Cement board cladding on front elevation & gables.

33 Haw ke Close Rustington

Planning application R/68/18/HH 33 Hawke Close, Rustington

NOTE 3

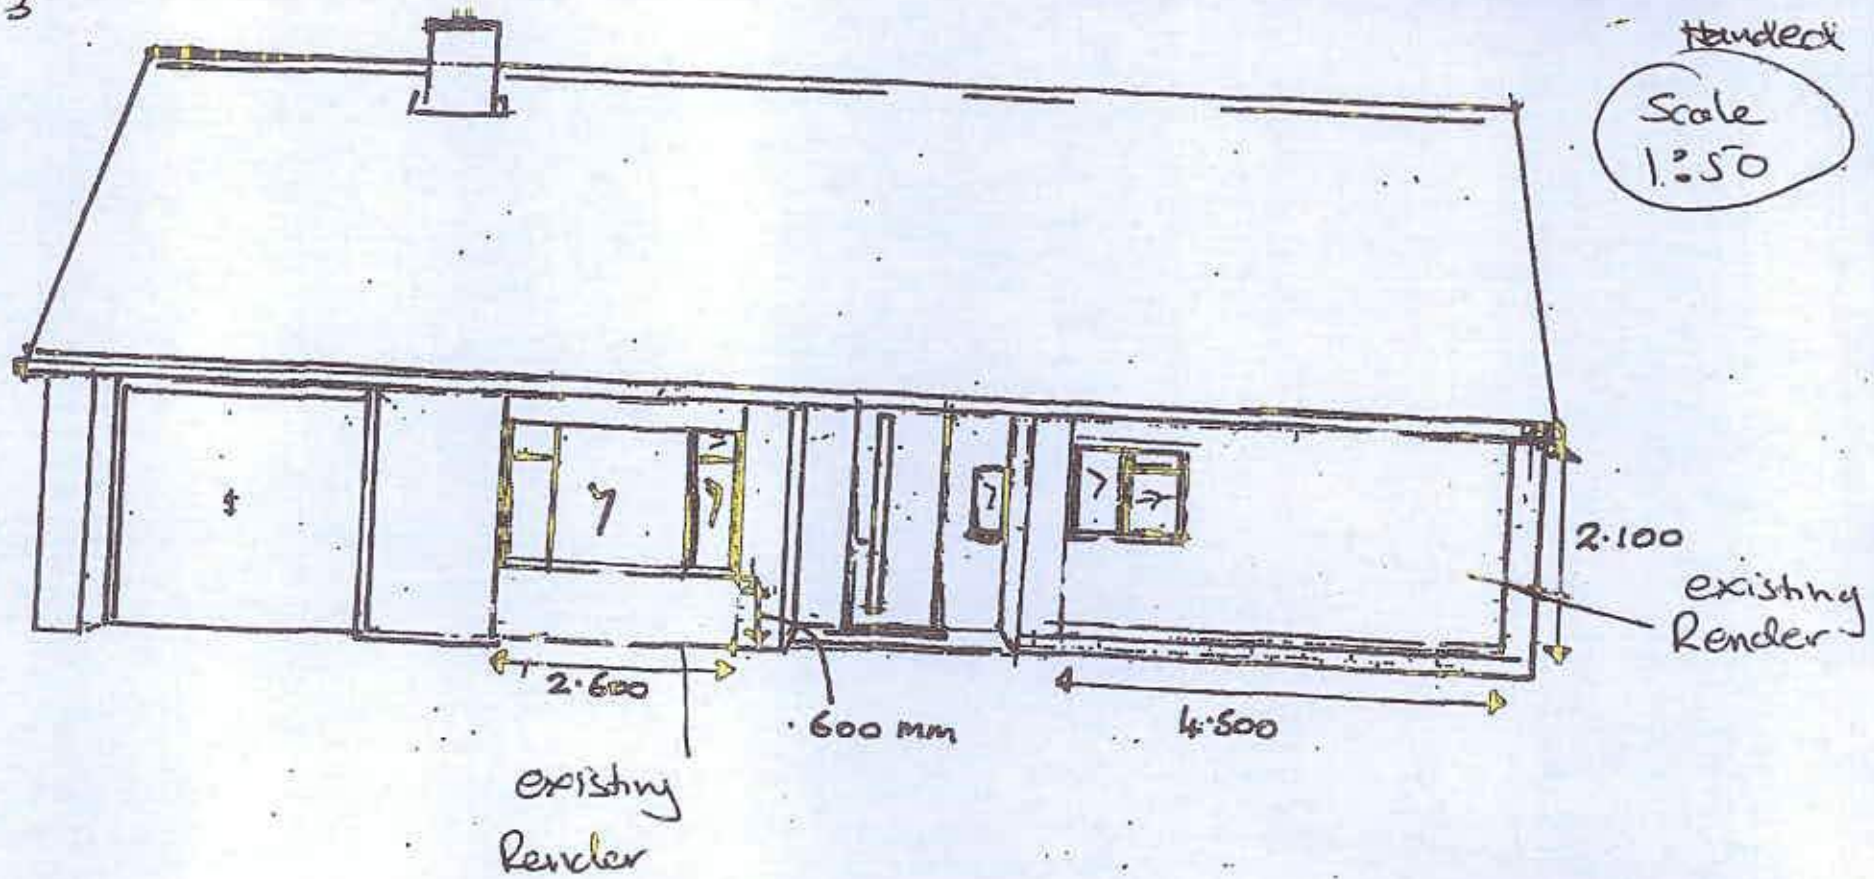
*Plan 3 is the wrong bungalow
Plan 4 is the wrong bungalow
Plan 5 is the same as Plan 6
Plan 6 is the same as Plan 5
Plan 7 is the wrong bungalow
Plan 8 is the wrong bungalow*
